EPC STORMWATER REVIEW COMMENTS
IN ORANGE BOXES WITH BLACK TEXT

Landscape Endeavors Building Addition

Commercial Construction Drawings

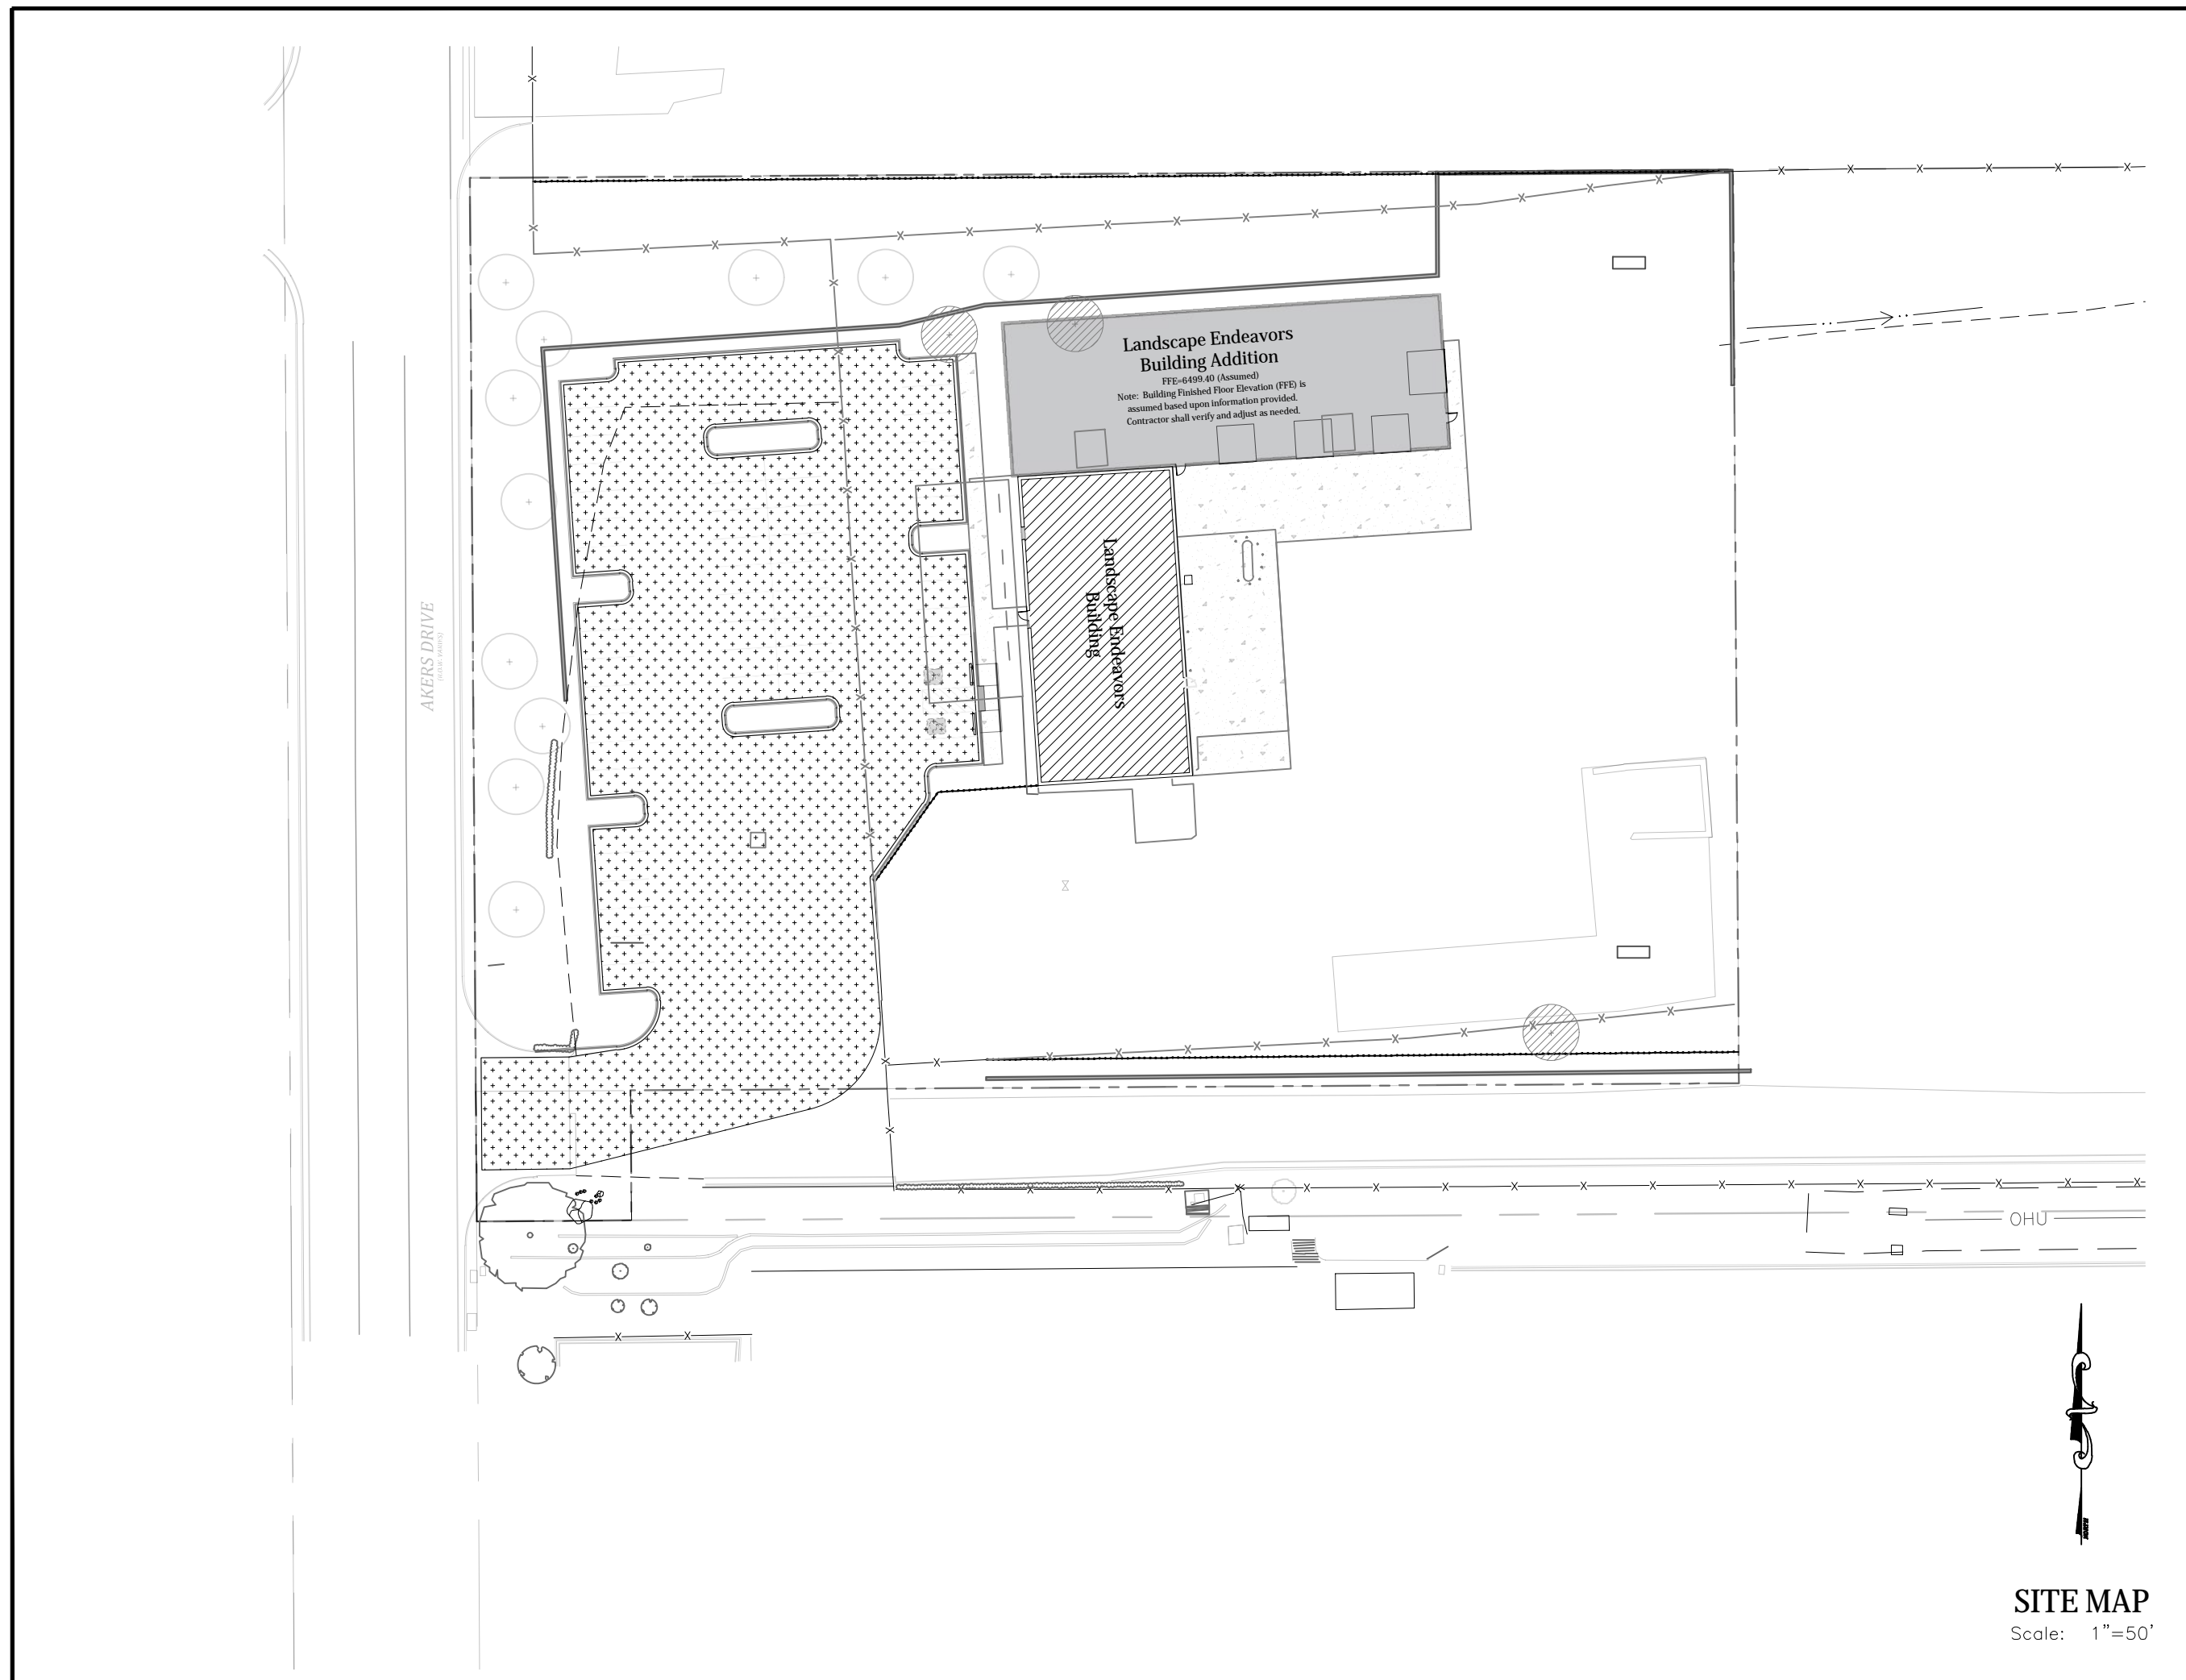
Note there is no public improvements such that construction drawings dont apply. The county will only be endorsing the GEC plan sheet set
